Mark Turner - Online Submission from Phil Duvollet of Pacific National (object)

**RE: REVIEW OF HUNTER 8 ALLIANCE MAITLAND TO MINIMBAH
ENVIRONMENTAL ASSESSMENT
MP 09_0024 and EPBC 2009/4897**

Subject: Proposed Maitland to Minimbah Third Track Project (Major Project Reference 09_0024 and Controlled Action Reference: EPBC 2009/4897)

**NOW COMMENTS ON ENVIRONMENTAL ASSESSMENT
ARTC MAITLAND TO MINIMBAH THIRD TRACK PROJECT (REFERENCE 09_0024 AND EPBC
2009/4897)**

Potential Blasting Locations

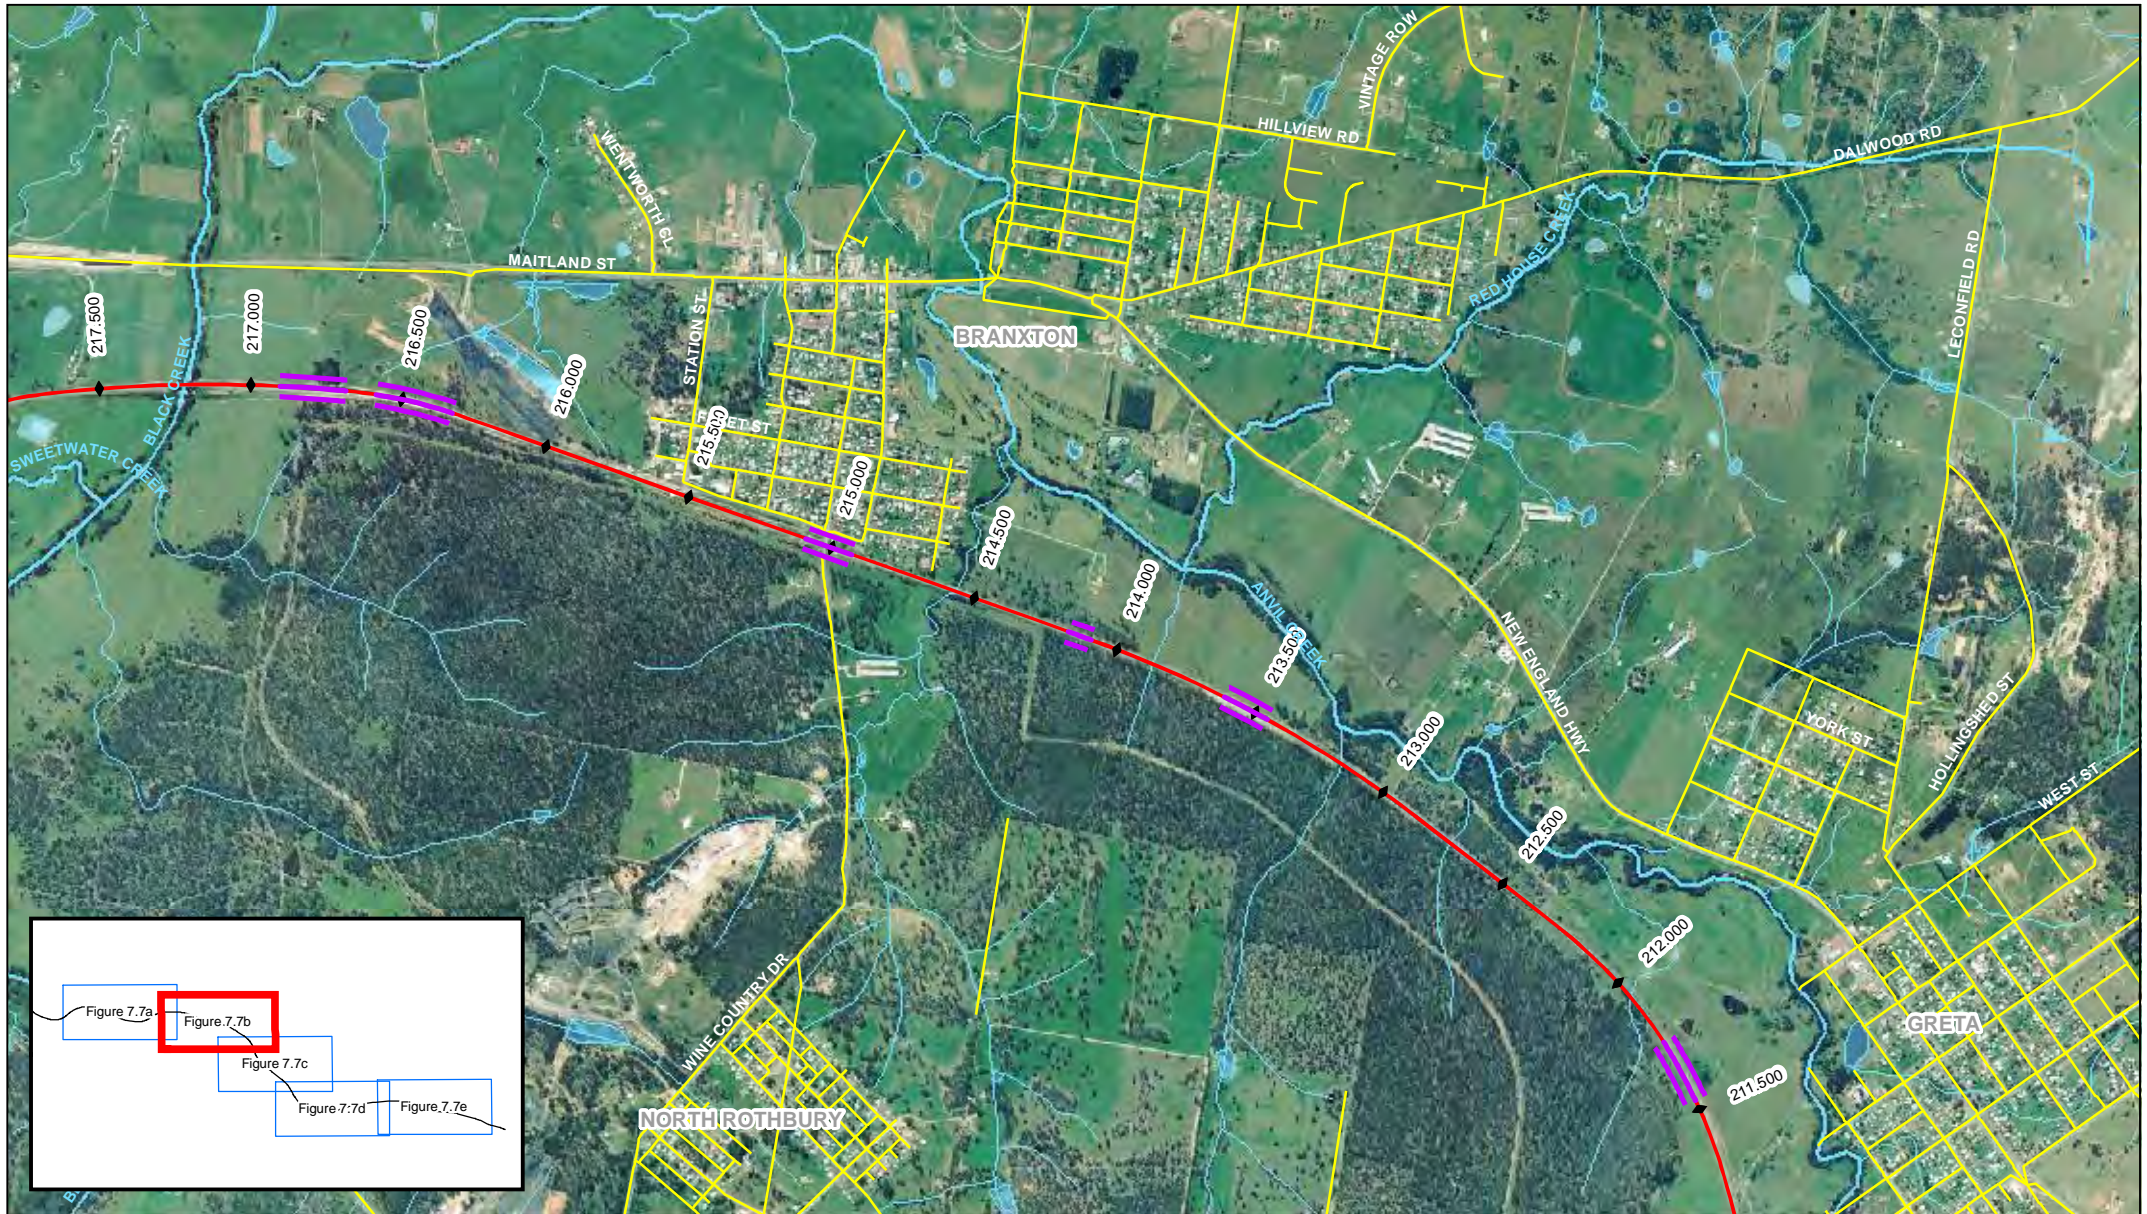
ARTC have identified a potential blasting location between chainage 211.540 and 211.760 adjacent to the Greta TSF site. The EA identifies that where sensitive receivers are within 500 metres of a blasting location, a full blasting design would be produced for all such locations. However, as noted above, the Pacific National Site is not identified as a sensitive receiver. **ARTC will be required to discuss this**

issue, along with any potential impacts/issues that may arise from blasting within close proximity of the Greta TSF and within a mine subsidence area.
